# CITY OF ALBUQUE

March 28, 2022

**Re: Dutch Brothers – 3615 Hwy 528**  
**ESC Plan Engineers Stamp Date: 3/23/2022 – A14E019**

DATE
03/23/2022

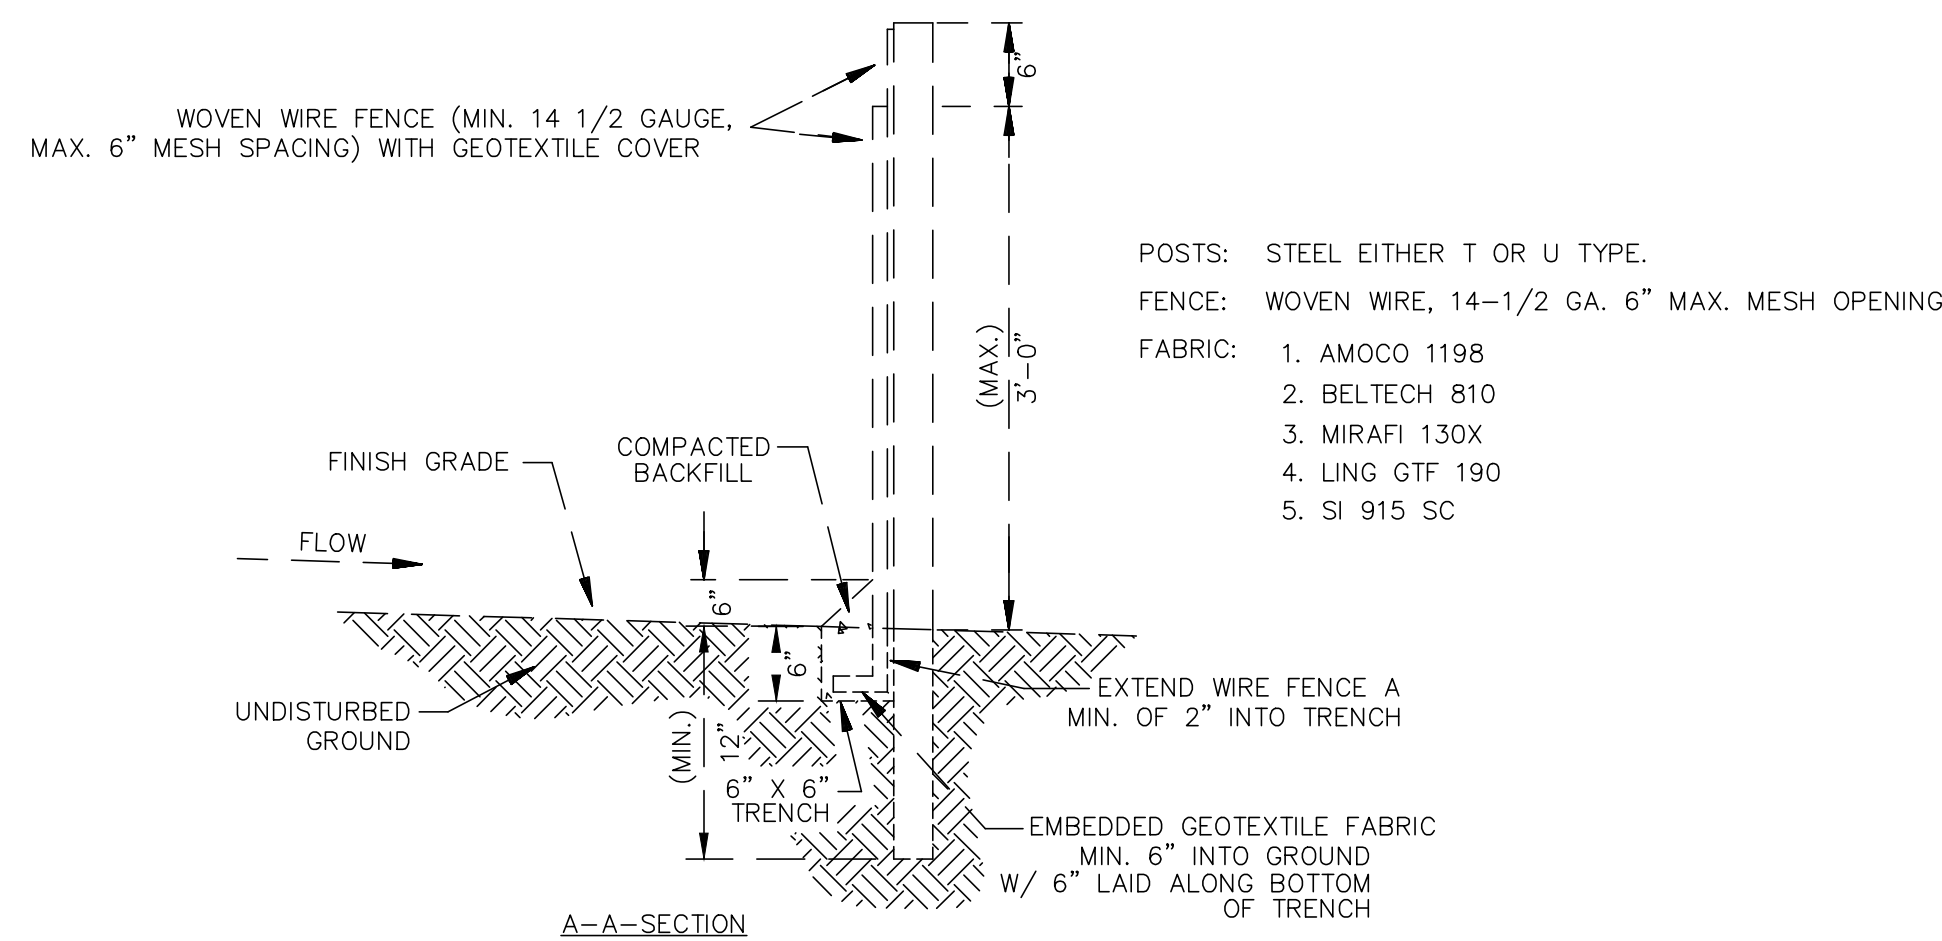
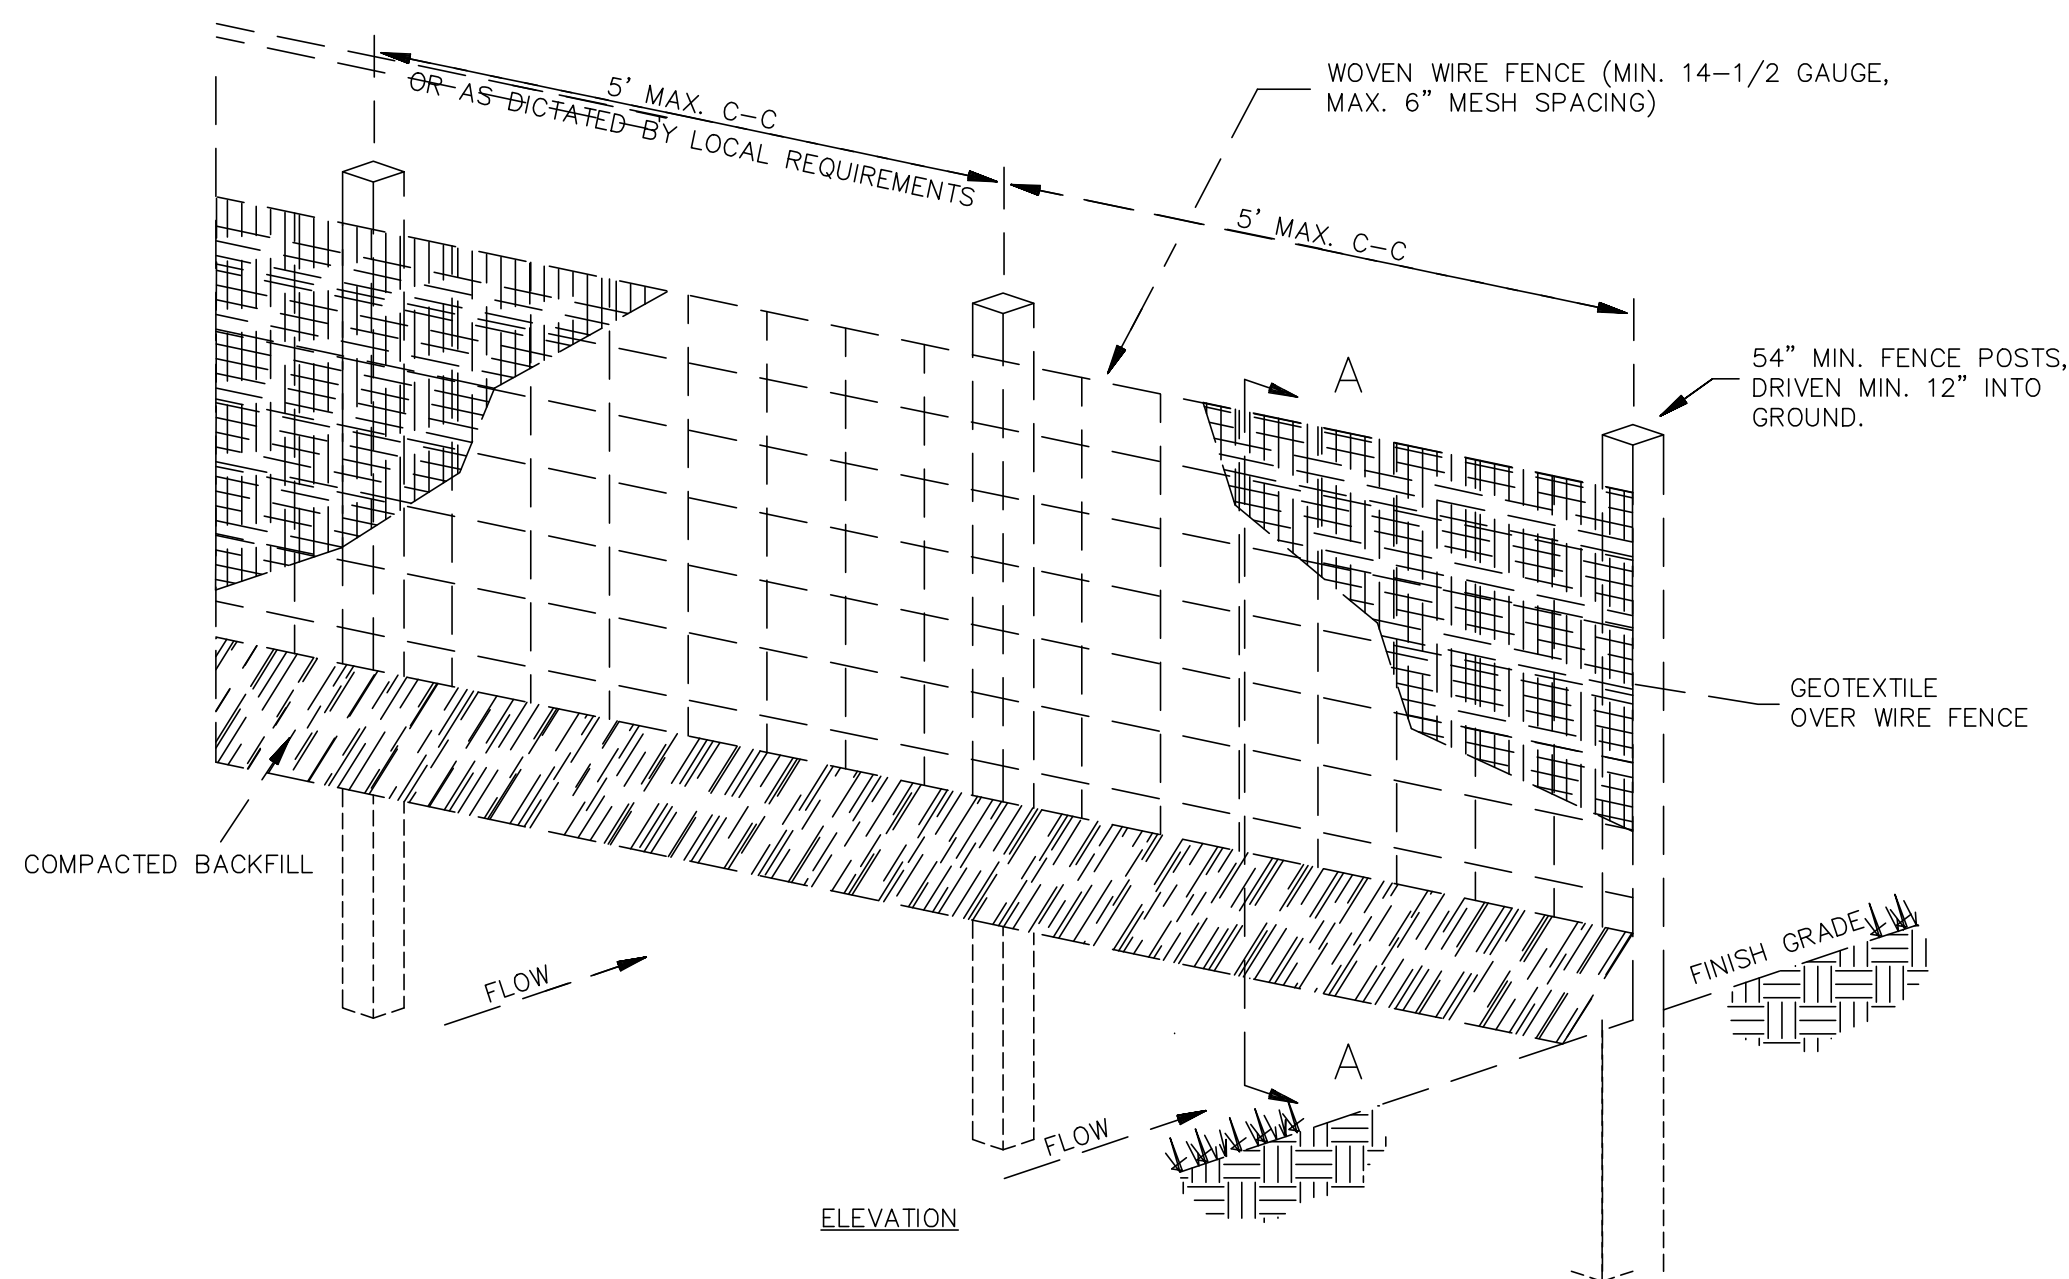
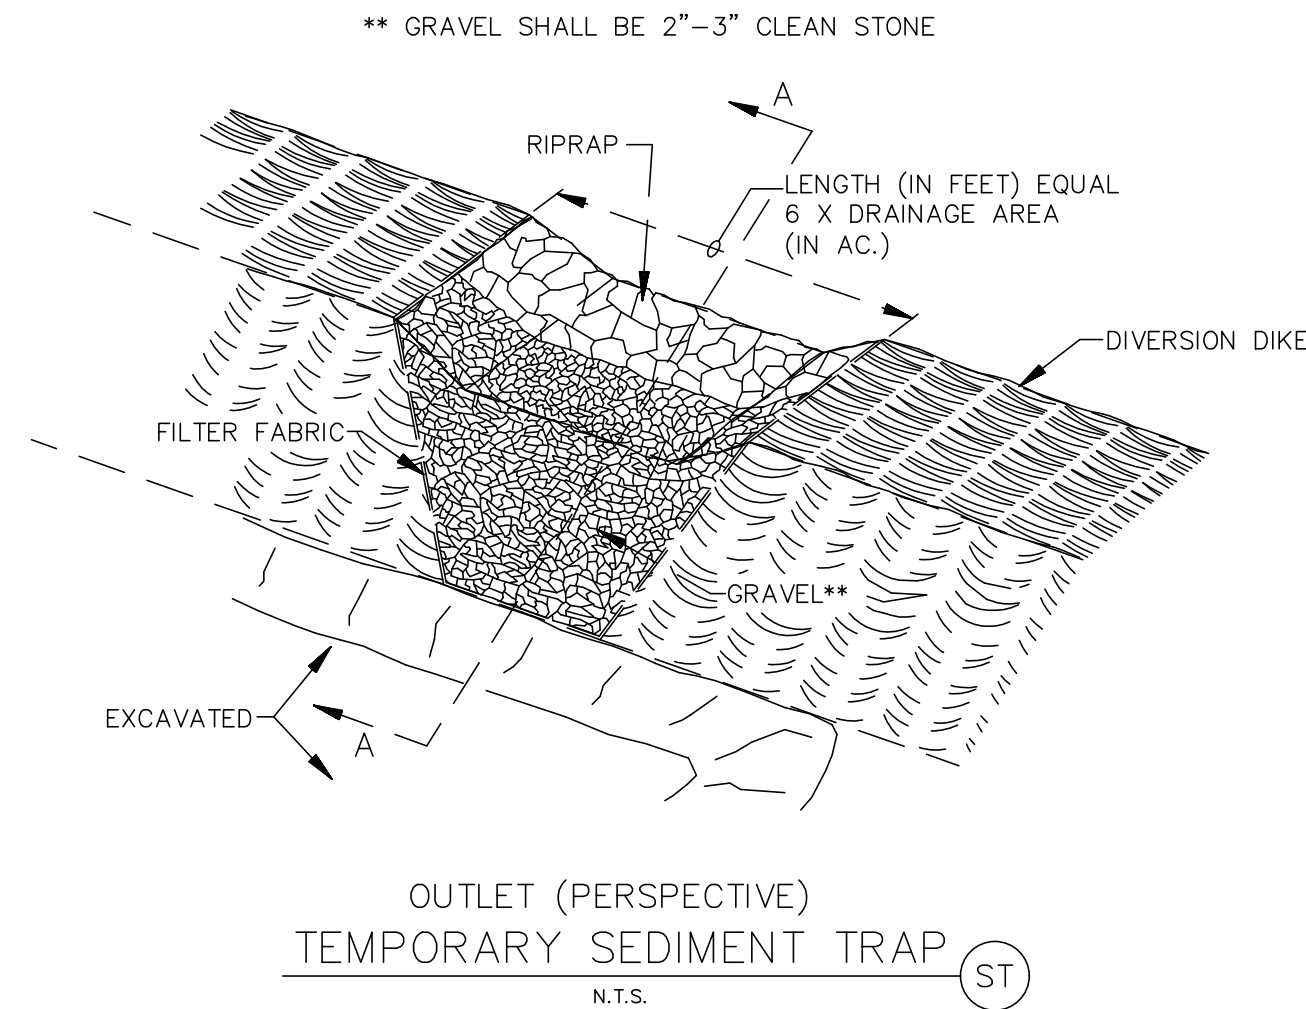
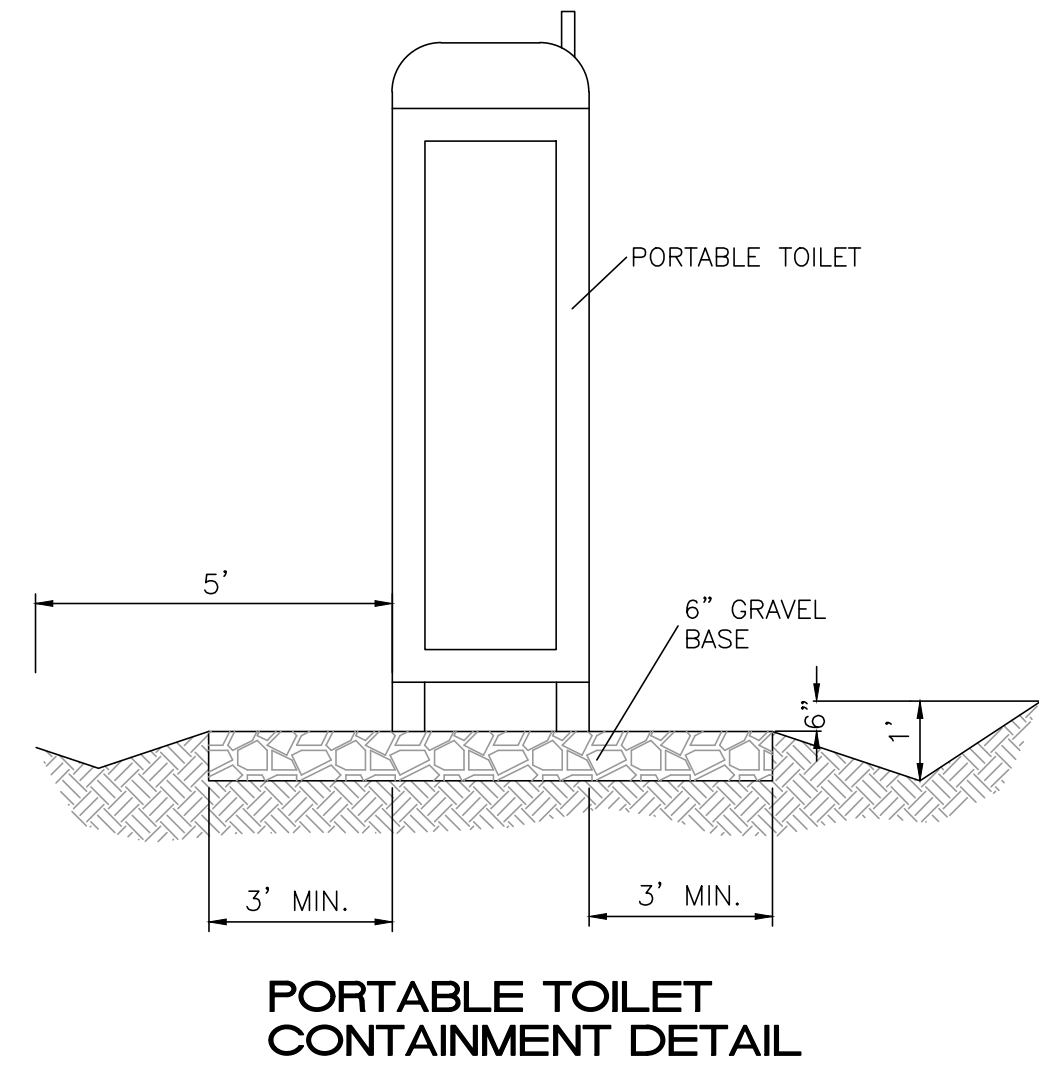
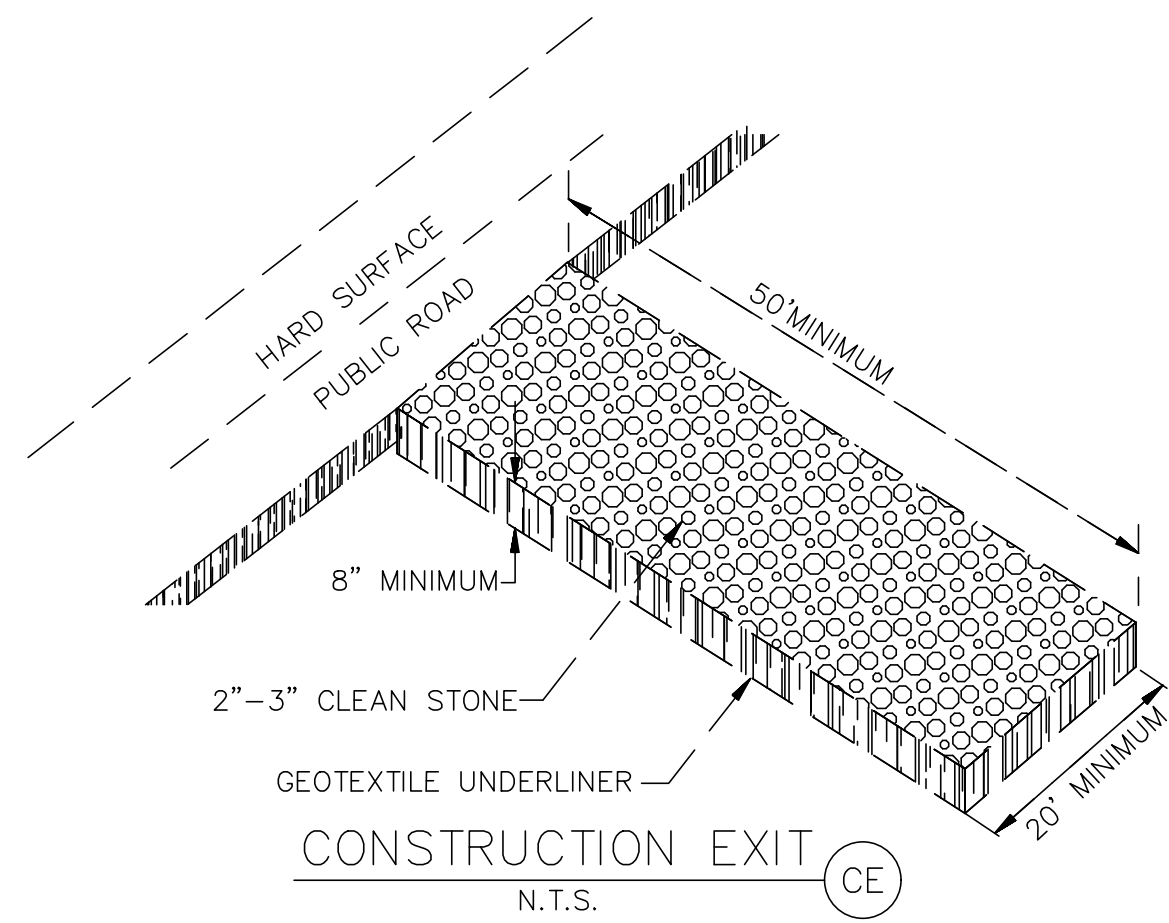
1. The limits of disturbance isn't shown. It must include all frontage improvements (CGP 7.2.4.b.i);
2. I can't tell the difference between building, sidewalk, asphalt, and dirt on the ESC Plan. These structures must be clearly identified in the SWPPP per CGP 7.2.4.b.vi. The same information is required in the ESC Application. You may attach a copy of the Site Plan to both the SWPPP and the ESC Application to address this requirement.

3. The SWPPP must include site-specific interim and permanent stabilization per CGP 9.4.1.c.i. The Landscape Plan and Work Order sheets can be used to satisfy this requirement and should be submitted separate from the ESC Plan with the application to the Stormwater Quality Section of the Planning Department and they should be included in the SWPPP. Provide a specification on the ESC Plan for any disturbed areas not covered by the Landscape Plan or Work Order sheets.

5. Update the engineer's stamp date each time the plan is changed.
